Stage 2D of the Sydney CityGrid Project

SUBMISSIONS RESPONSE AND PREFERRED PROJECT REPORT

FEBRUARY 2011

Figure 6-1 Horizontal alignment of the CECT

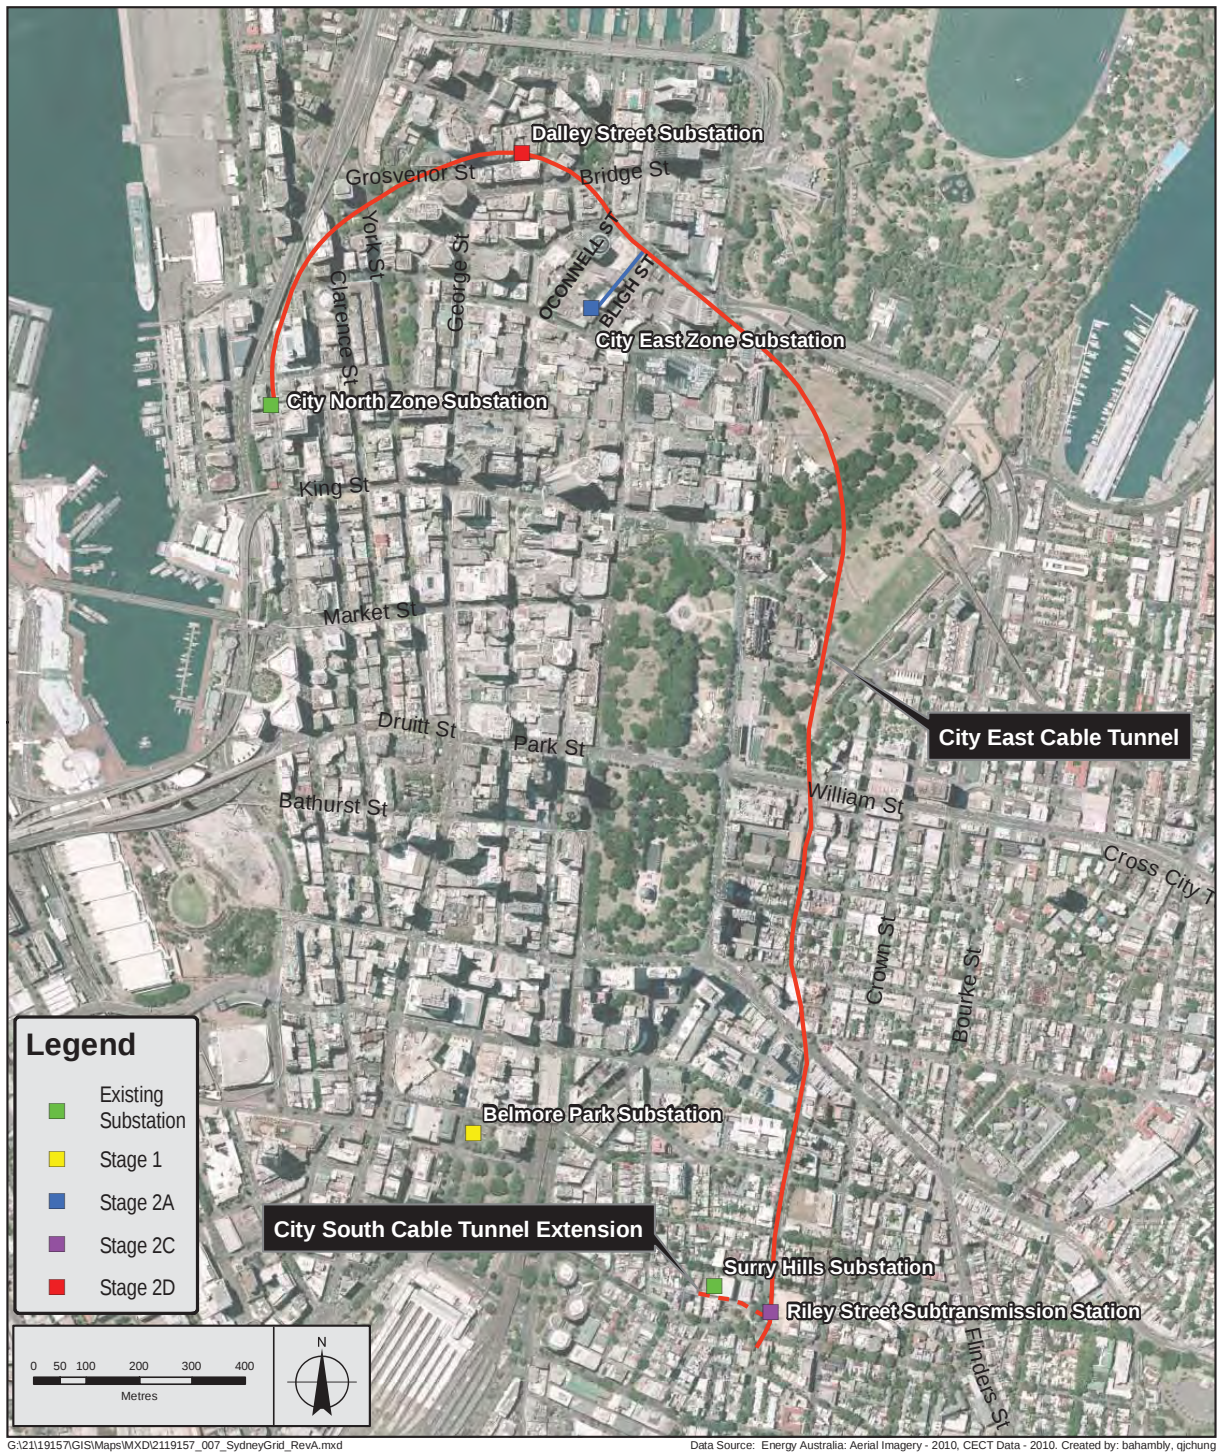
- Construction of the Dalley Street shaft must be carried out with archaeological input as the site has the potential to contain archaeological remains associated with the history and development of Sydney, including the Tank Stream;

- If construction of the shaft impacts on any archaeological remains, including the Tank Stream, EnergyAustralia must investigate alternative locations for the Dalley Street shaft, giving consideration to existing services and utilities located within the vicinity of the area;

The project has been refined and it is not longer proposed to refurbish the Dalley Street Zone Substation, meaning that a shaft is no longer required in Dalley Street (refer to Section 3). Based on this, it is no longer considered necessary to include specific commitments or conditions relating to managing potential heritage issues associated with construction of a shaft in Dalley Street or refurbishment of the Dalley Street Zone Substation.
